Recommendation Report for Planning Permission for Works or Extension to a Dwelling

REF NO: FG/161/25/HH

LOCATION: 9 Somerset Road
Ferring
BN12 5QA

PROPOSAL: Loft conversion including roof extensions, front dormer and rooflights, and garage conversion with alterations to fenestration.

Proposed Ground Floor Plan, Scale 1:50

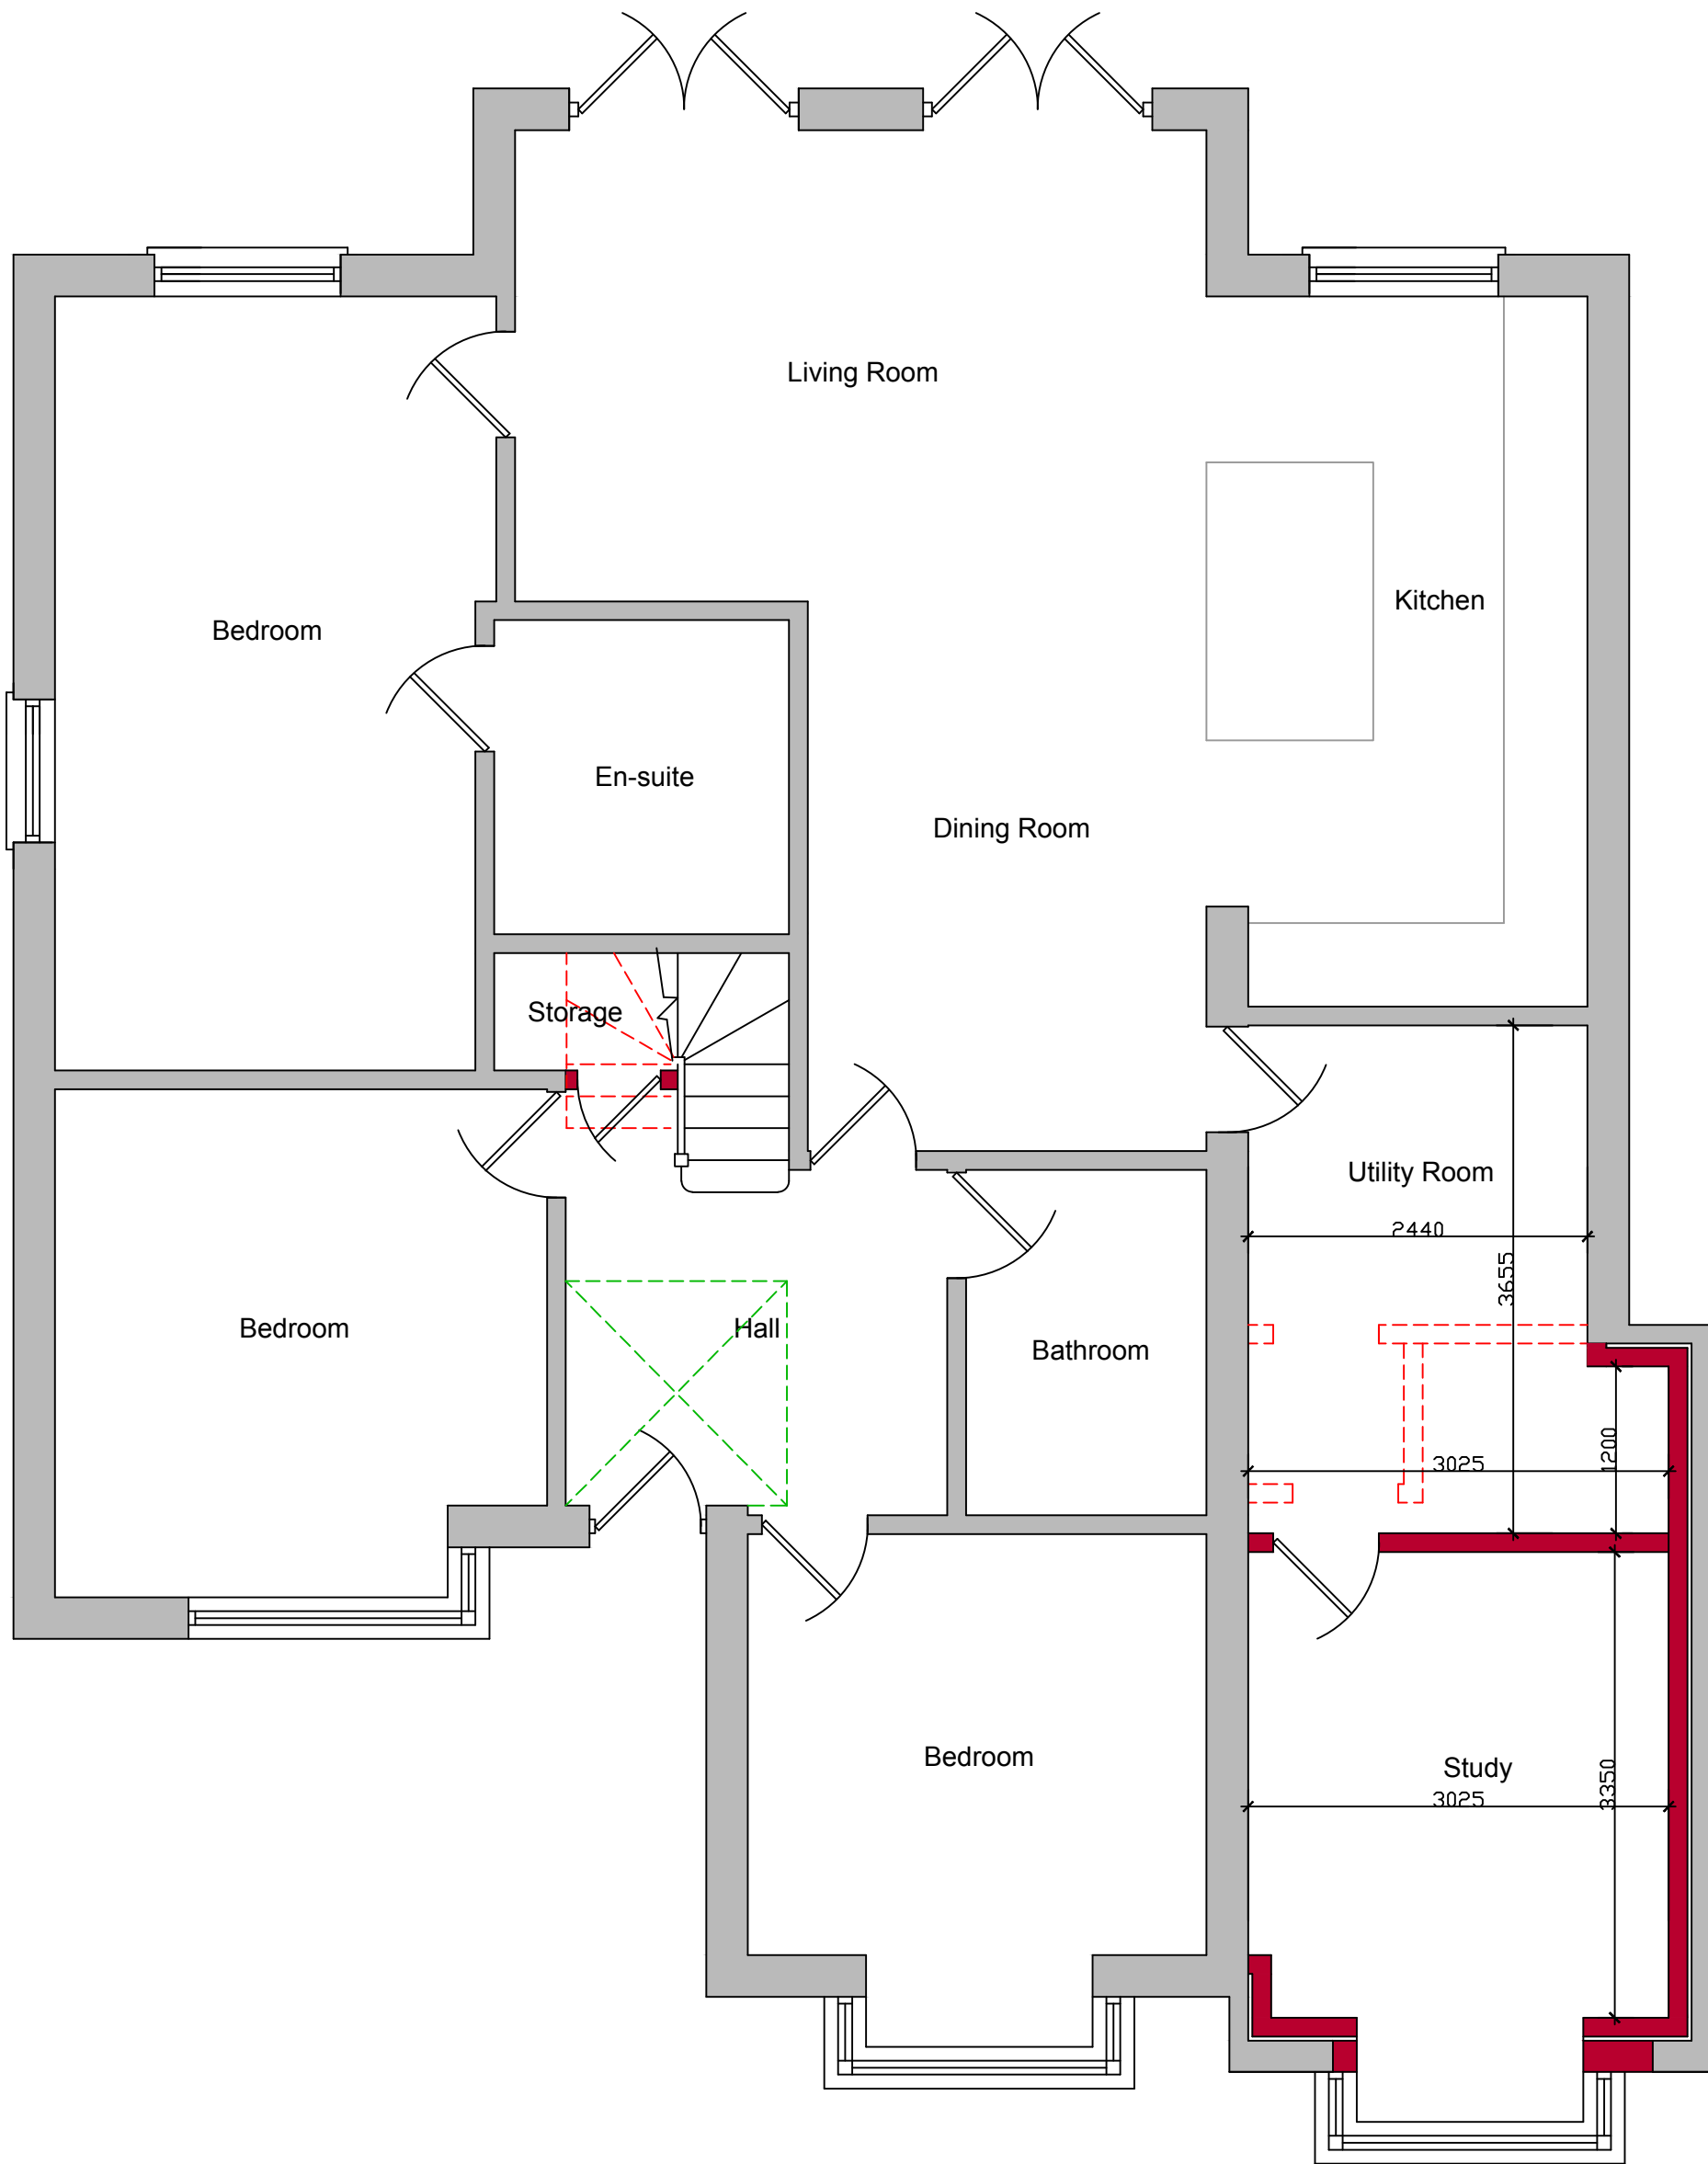
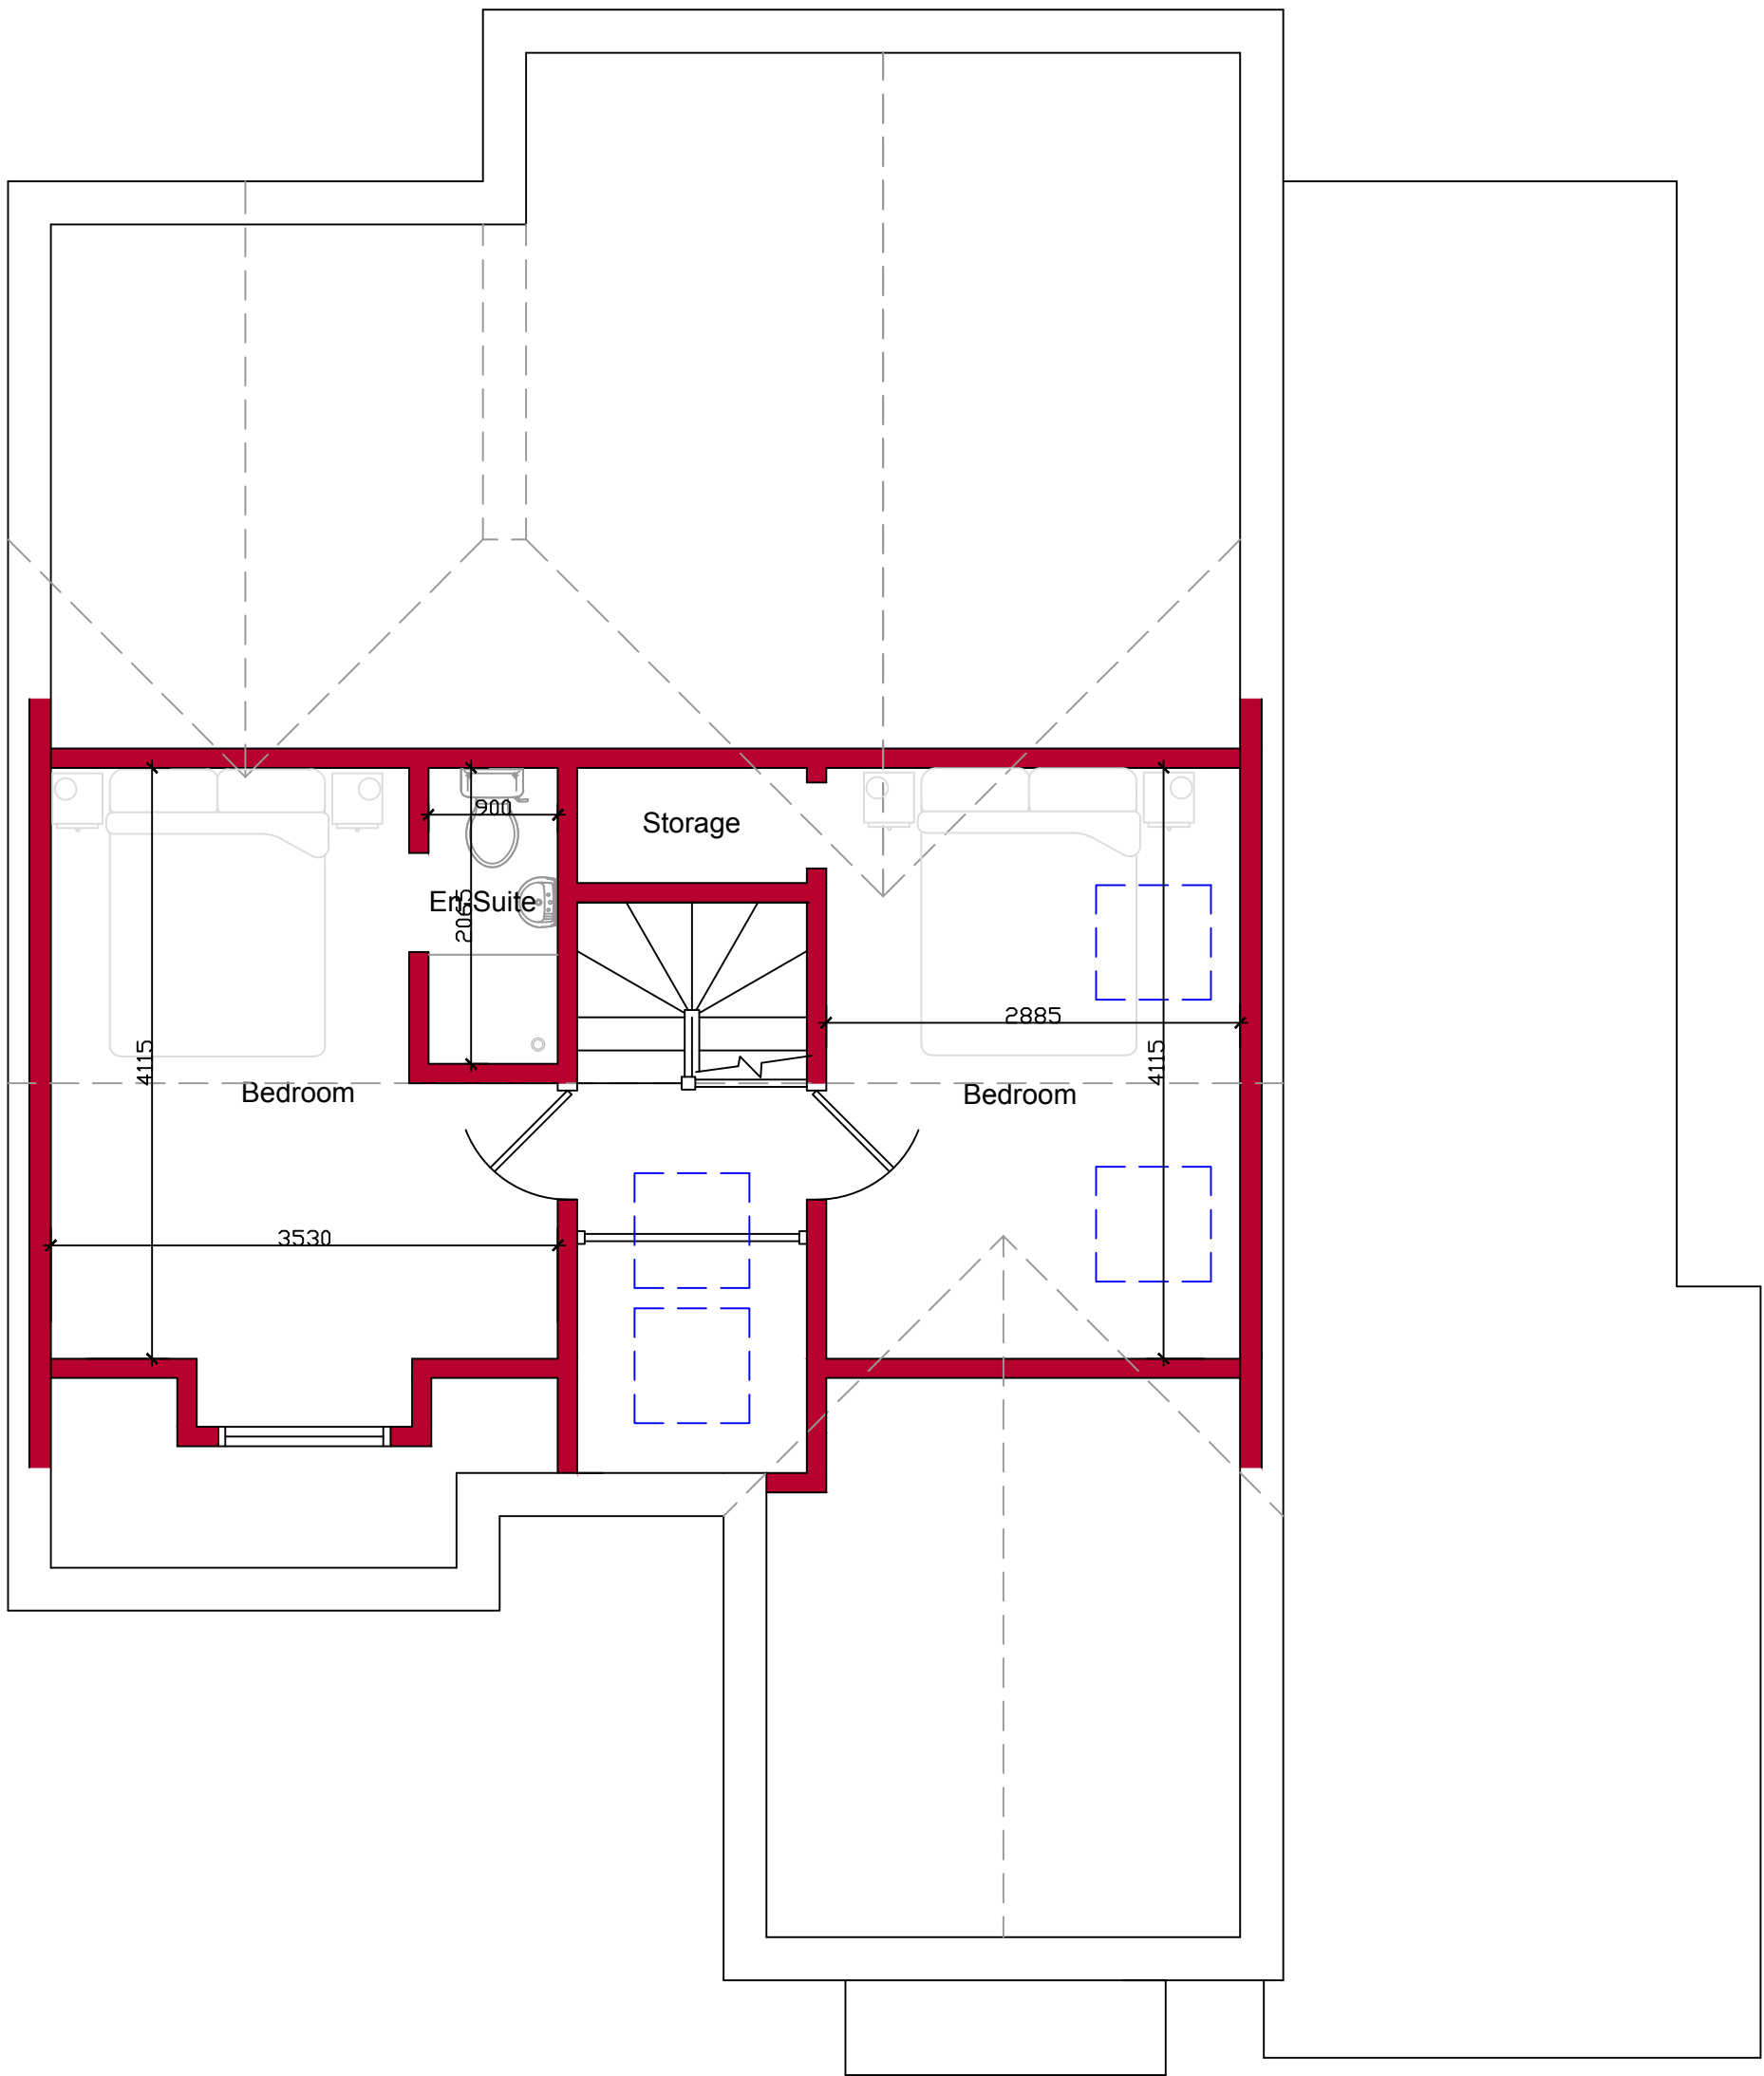
The proposed front (south) dormer would have a depth of 2.5m and a width of 2.2m, with a height of 2.1m. Within the front (south) roof plane would be three rooflights and it is noted that there are other dwellings within the surrounding area that have roof lights within their roof planes. The proposed dormer would reflect the character of the host dwelling, with a pitched roof form and would be a subservient addition to the front roof slope. The proposed rooflights would be proportionate in scale and number, and would not result in any harm to visual amenity.

The proposal would convert an existing garage into habitable use with the proposed extension of a bay window to the front elevation, with a depth of 0.65m and a width of 2.4m. The proposed bay window would have a flat roof with a height of 2.4m, integrating into a dummy pitched roof within the existing bay window at the front of the dwelling. The proposal would not exceed the maximum depth of 1.5m to front extensions, outlined within the ADG. Furthermore, the street scene is varied in terms of extensions and alterations, and as such, the proposed front extension would not result in harm to visual amenity and would not appear unduly prominent within the street scene. The proposed fenestration within the front elevation would include a four-casement window to match the existing. The proposed fenestration would be appropriate and proportionate and would therefore be acceptable in this regard.

The proposal would convert an existing garage into habitable use and would be set back from the front boundary of the application site by approximately 6.75m and set in from the western side boundary by approximately 12.5m. It is noted that proposed single storey front extension does not extend significantly forward of neighbouring dwellings and given the spacing maintained between the extension and neighbouring properties, the proposed front extension would not result in harm through overshadowing or overbearing impacts to neighbouring dwellings. The proposed fenestration would have an outlook of the front amenity serving the host dwelling and would not result in overlooking or loss of privacy to the neighbouring dwellings.

The proposed roof extensions, loft conversion, and front (south) dormer would maintain existing separation distances of 3m on the western side boundary and 3.5m on the eastern side boundary between the host dwelling and neighbouring properties. Whilst the proposed roof extensions would increase the bulk and massing of the dwelling, given the maintained spacing the proposal would not result in harm by way of overshadowing or overbearing.
